Consultation Response from KC, Highways Development Management
2026/91304 Rose And Crown Inn, 132, Knowl Road, Golcar, Huddersfield, HD7 4AN
Variation condition 2 (plans) 9 (drainage), 10 (drainage), 14 (highways) and 17 (provision of footway) on previous permission 2024/90839 for erection of 7 dwellings and associated infrastructure following partial demolition of existing public house (within a Conservation Area)
Date Responded: 24 June 2026 Responding Officer: Sheila Henley Responding Ref: 2-3NE/18

Recommendation: Additions and revisions.

Plan Ref: 3683 (0-) 10C Proposed Site Plan; 2376-0007 rev B - Highway Boundary; 2376-0006A - Bus Shelter; 2376-0005B - Typical Sections; 2376-0004A - Cross Sections; 2376-0003A - Long Sections; 2376-0002B – Contours; 2376-0001E - Kerbing & Surfacing; 3683 (0-) 08B - Plot 6; 3683 (0-) 09C - Plot 7.

DRAWING TITLE
LONG SECTIONS

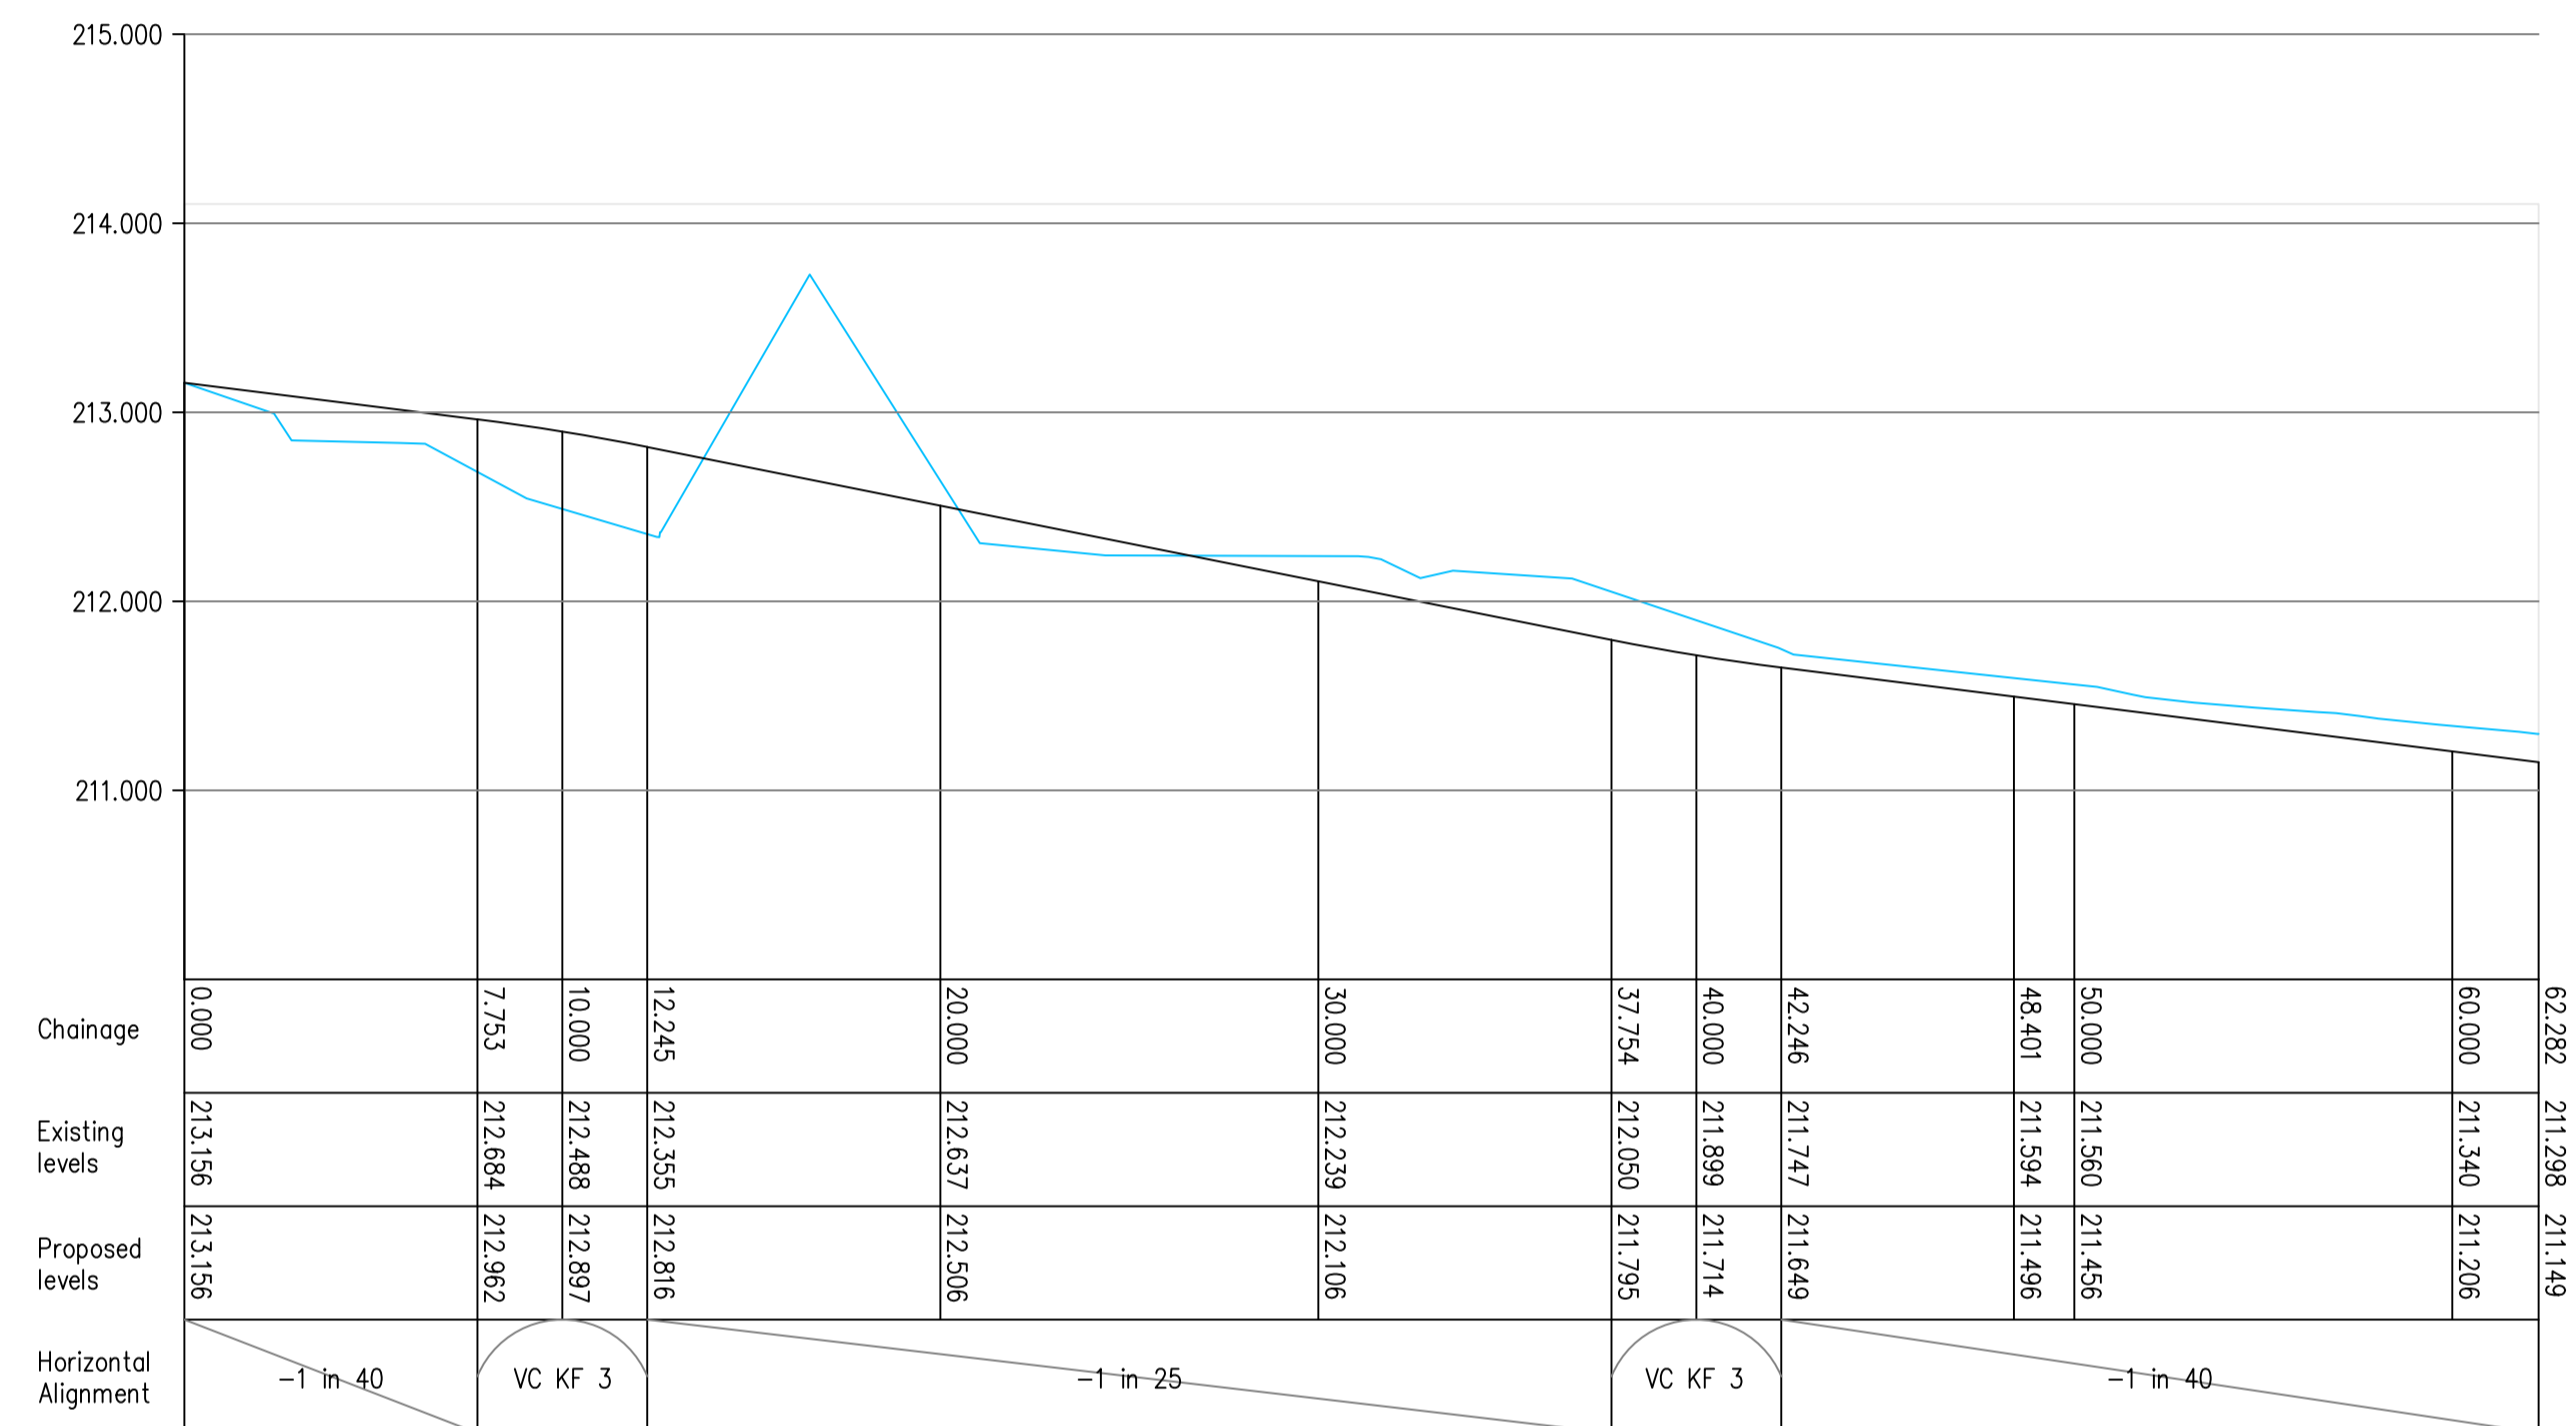
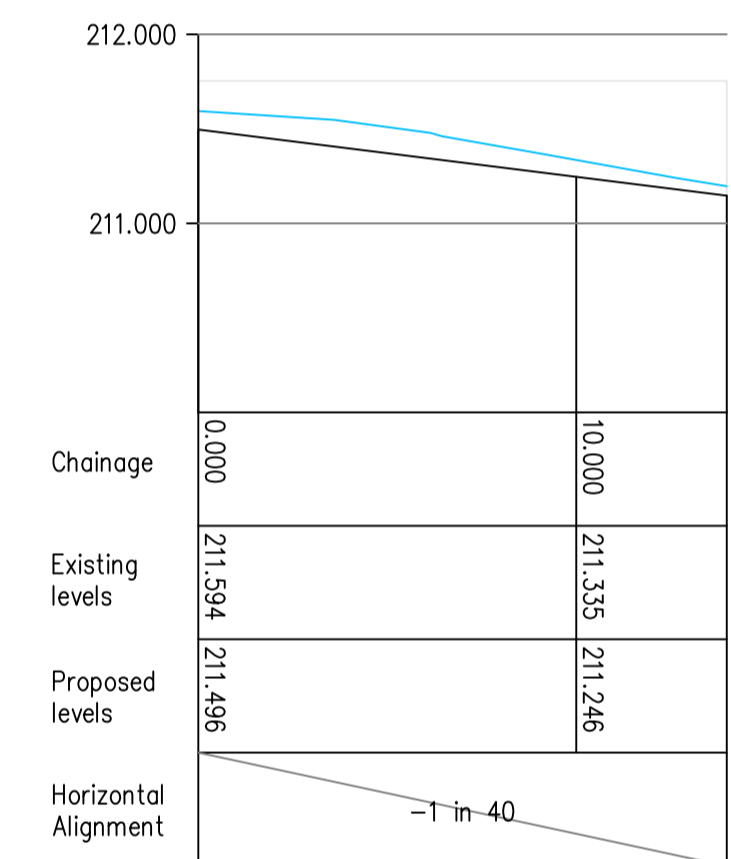
The shared surface carriageway must have speed restraint features every 40m and not be steeper than 1:21 or 5% otherwise a Local Residential Street (Type B) with footways on both sides will be required. The sections of footway can be removed from the adjacent the shared surface carriageway if these exceed the 2m beyond the transition ramp and if the gradients permit.

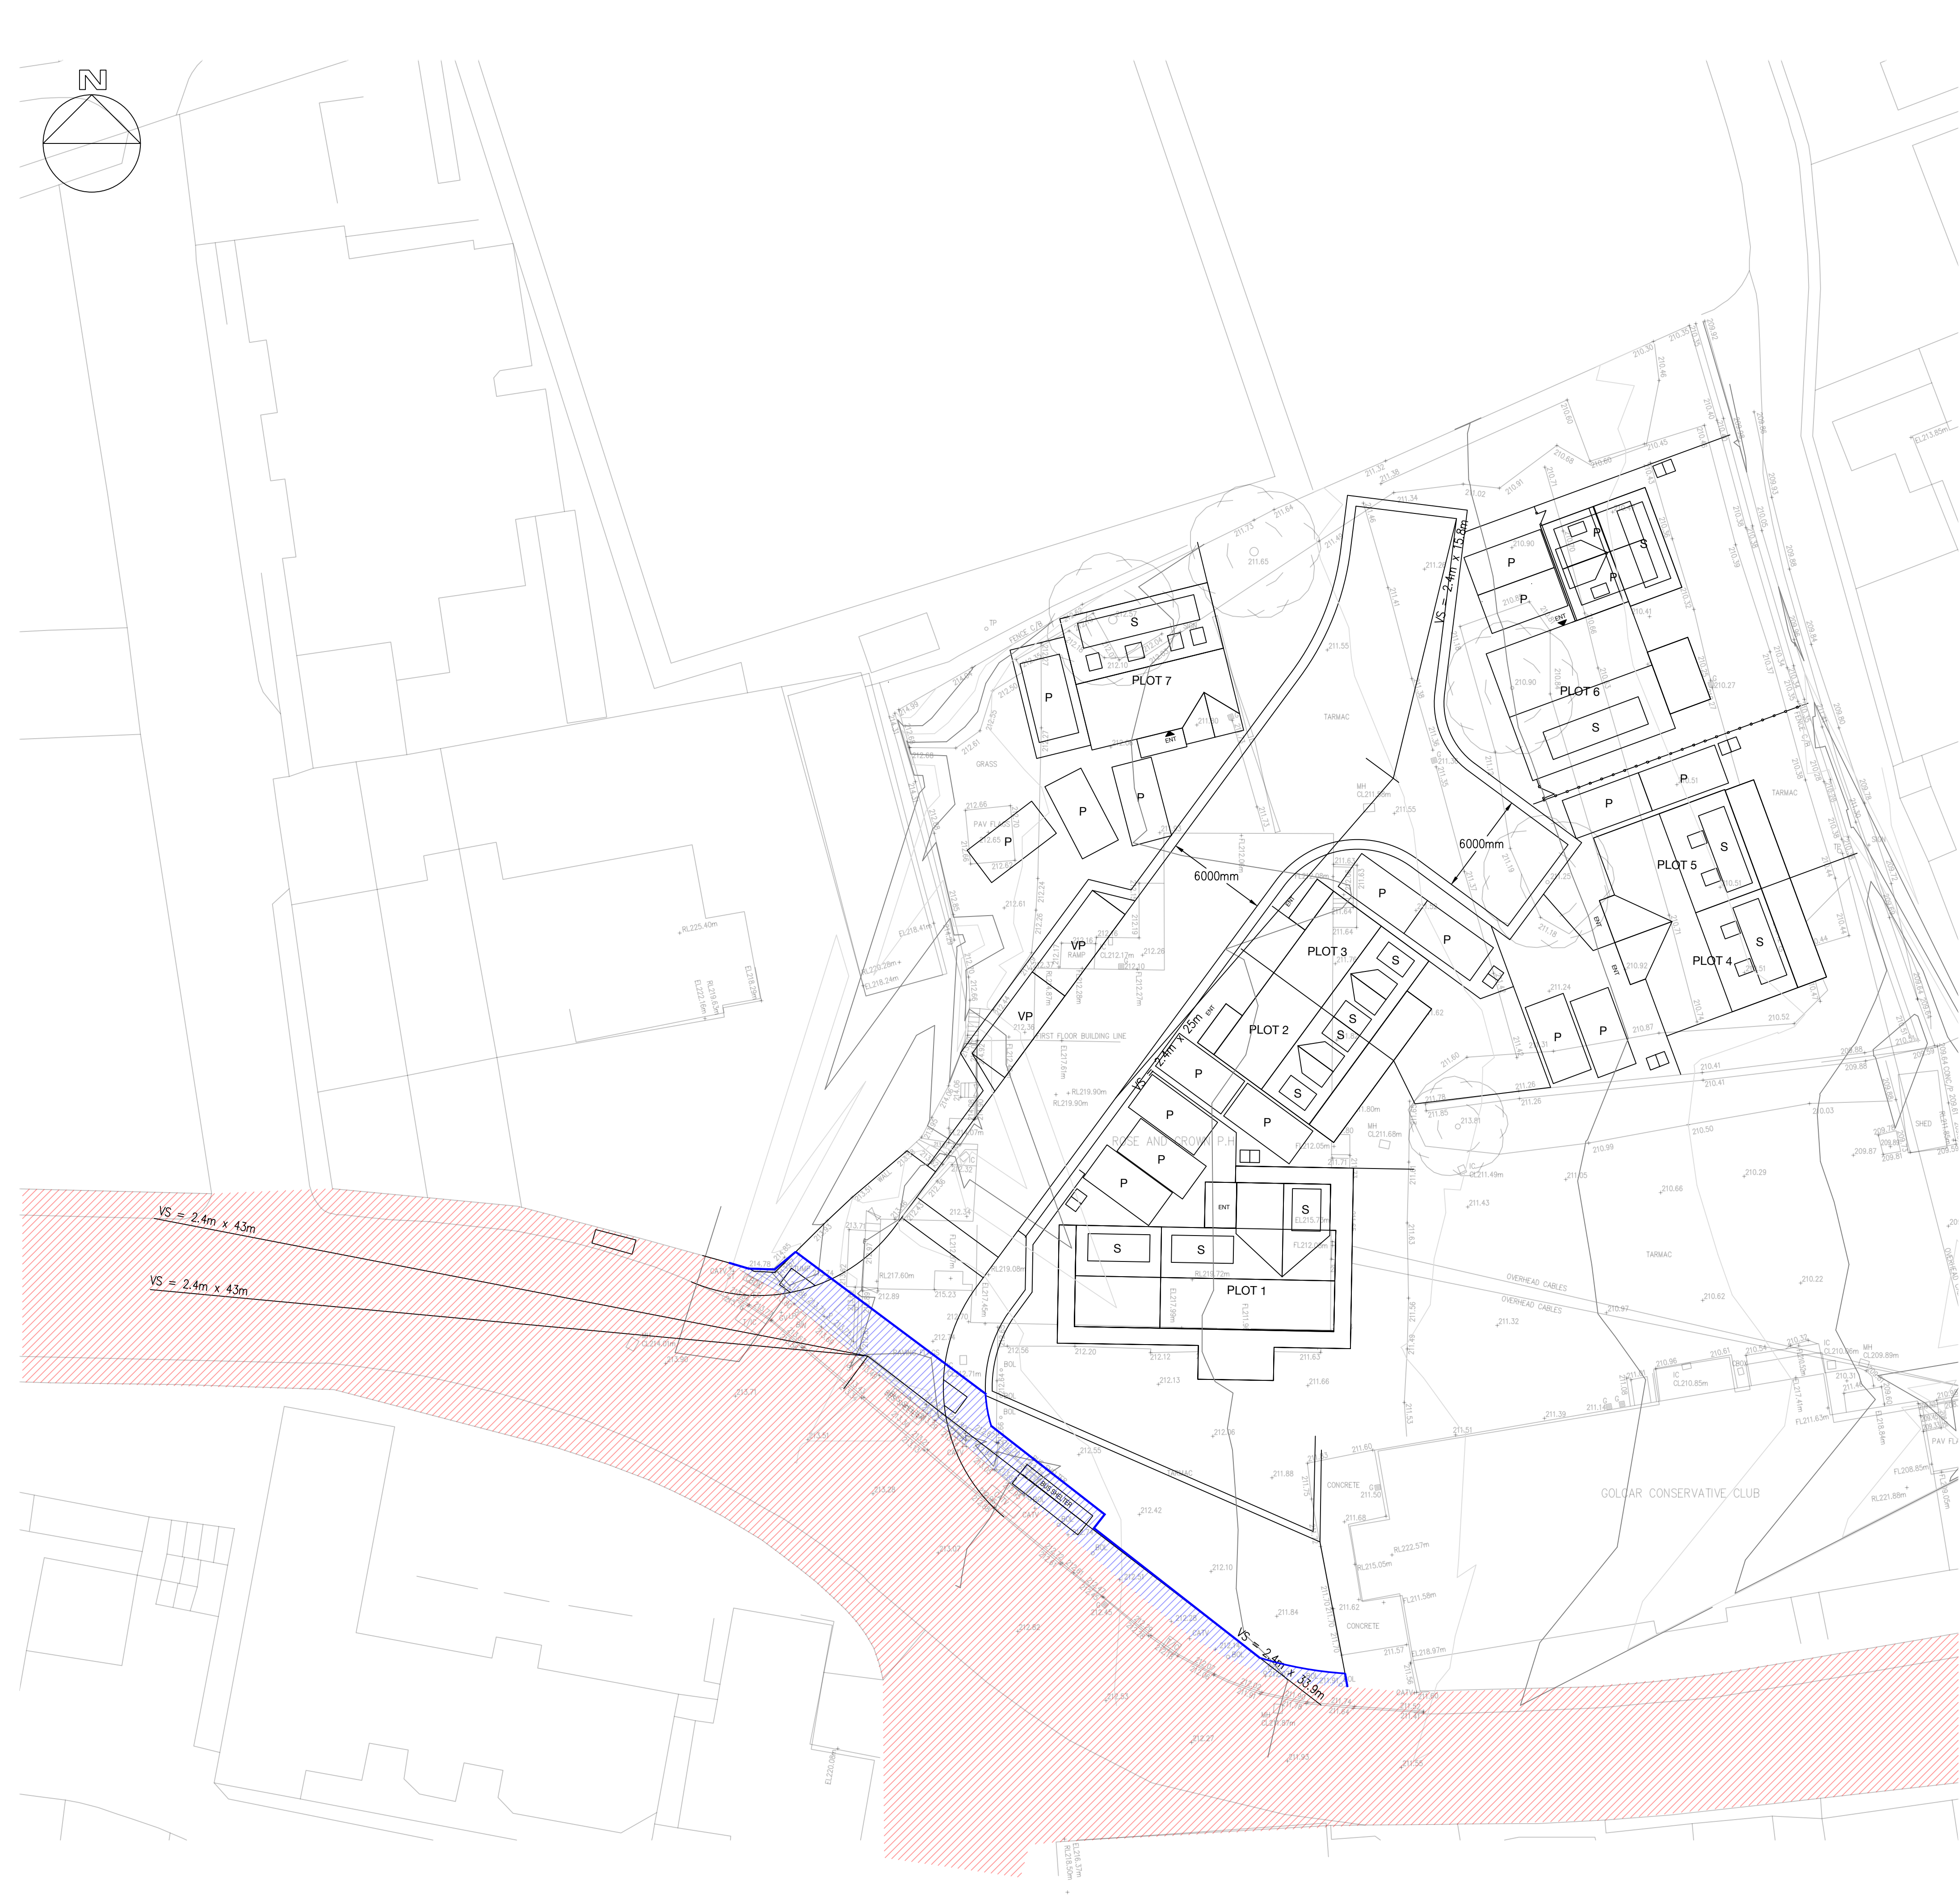
The submitted highway boundary as well as the kerbing and surfacing details do not accord fully with geometric and technical requirements. Additionally, there is an over reliance on past approvals and some inconsistencies between plans. Specifically, it is unclear if the footway to be provided around the western junction radii is in accordance with the standard detail as below with footways on both sides of the carriageway and 2.0m beyond the transition ramp into a shared surface carriageway. A footway is indicated on the Proposed Site plan to continue, but it needs to be reflected more legibly on the highway boundary plan.

On the highway boundary plan there are no visibility splays indicated at the junction to the existing road however the 2.4m x 43m splay to the west also requires the secondary visibility splay as the junction is located to a bend as per the extract below from Manual for Streets.

The visibility splay 2.4 x 33.9m to the east is sub-standard for a 30mph speed limit and it is unclear how this was derived. It does reflect past consents including 2022/90469, but confirmation is necessary as to whether this is a maximised extent or reflects a lower recorded speed profile and the 85th percentile speeds from a recent speed survey. If this is not the case additional vertical or horizontal traffic calming will be required to ensure the appropriate speed is self-enforcing.
